From: Paul Quantrill [REDACTED]
Sent: 17 October 2018 16:54
To: Richard Castro-Parker
Subject: Re: FW: AW/85/18/HH - 54 Kingsway material details.

Please see the conservation Officers latest comments re: : AW/85/18/HH -- 54 Kingsway. Further to my voicemail message I require details re: the external materials:

AW/85/18/HH

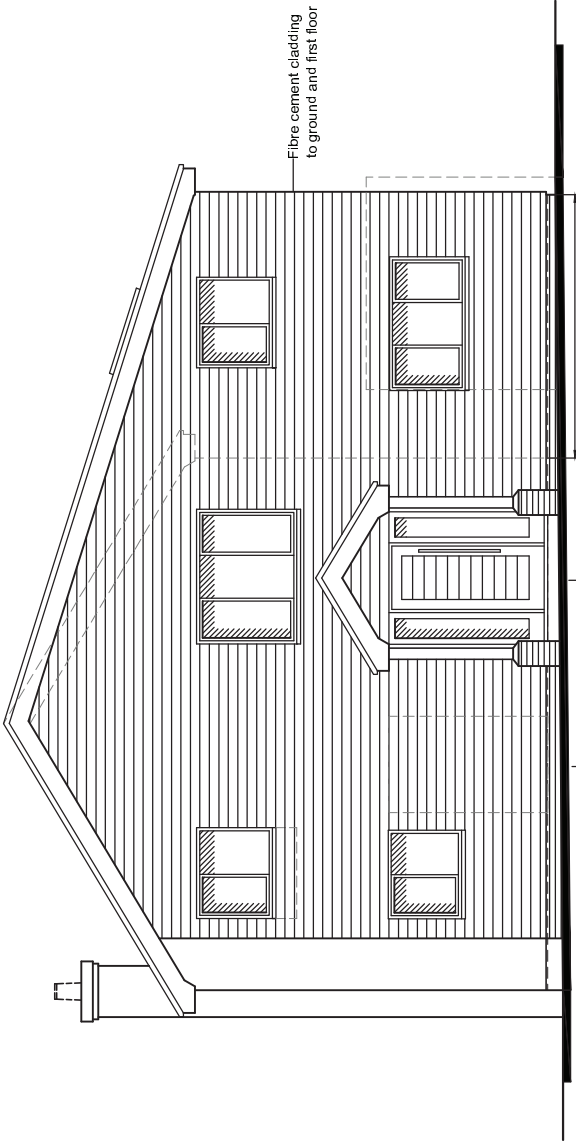
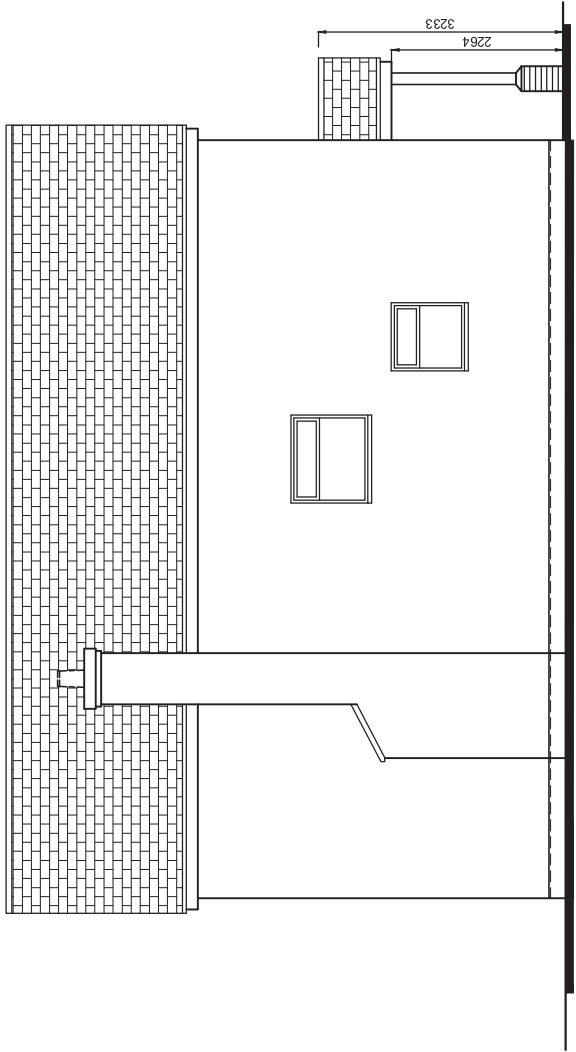
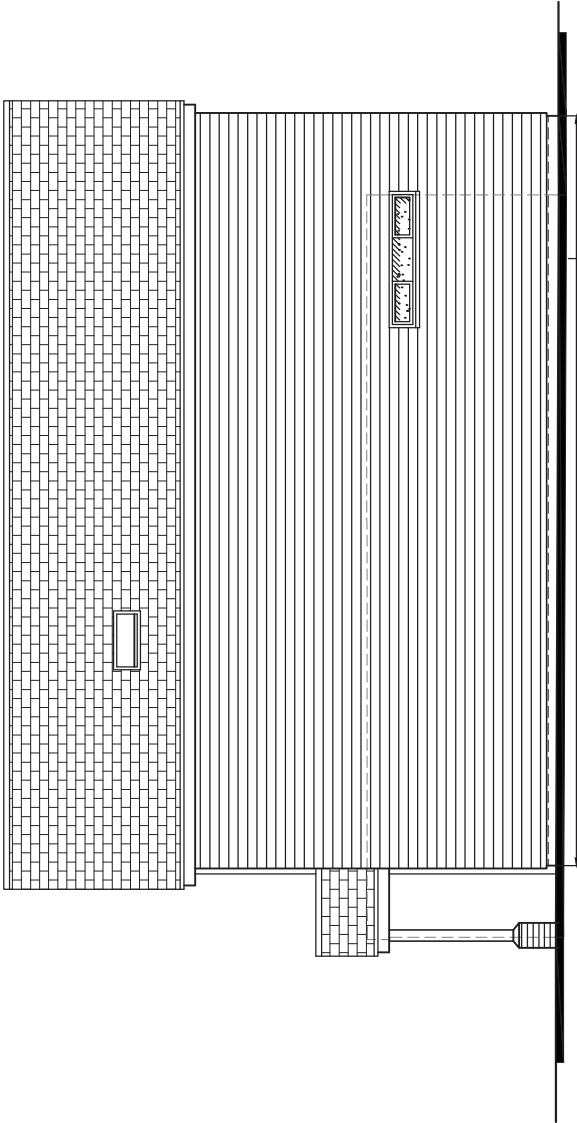
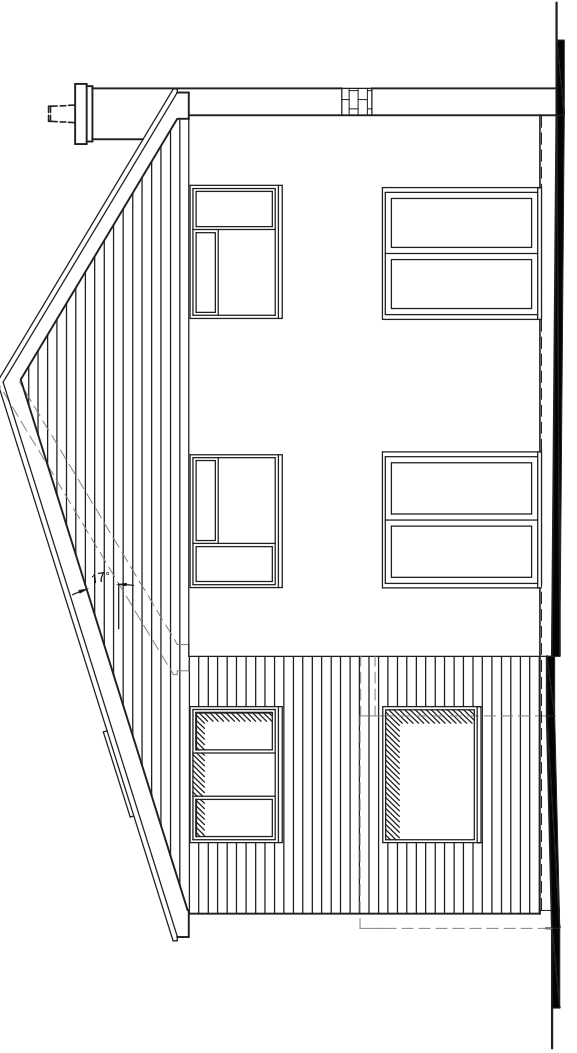
The revised proposal is therefore considered to be more in keeping with the properties within the local area, i.e. through the use of render on the front elevation. However, it is not clear from the plans what the cladding will look like, or what colour it will be. There is also limited information as to the colour of the windows, front door, and roofing materials. Such detail will affect the impact of the proposal upon the local area, and should be provided.
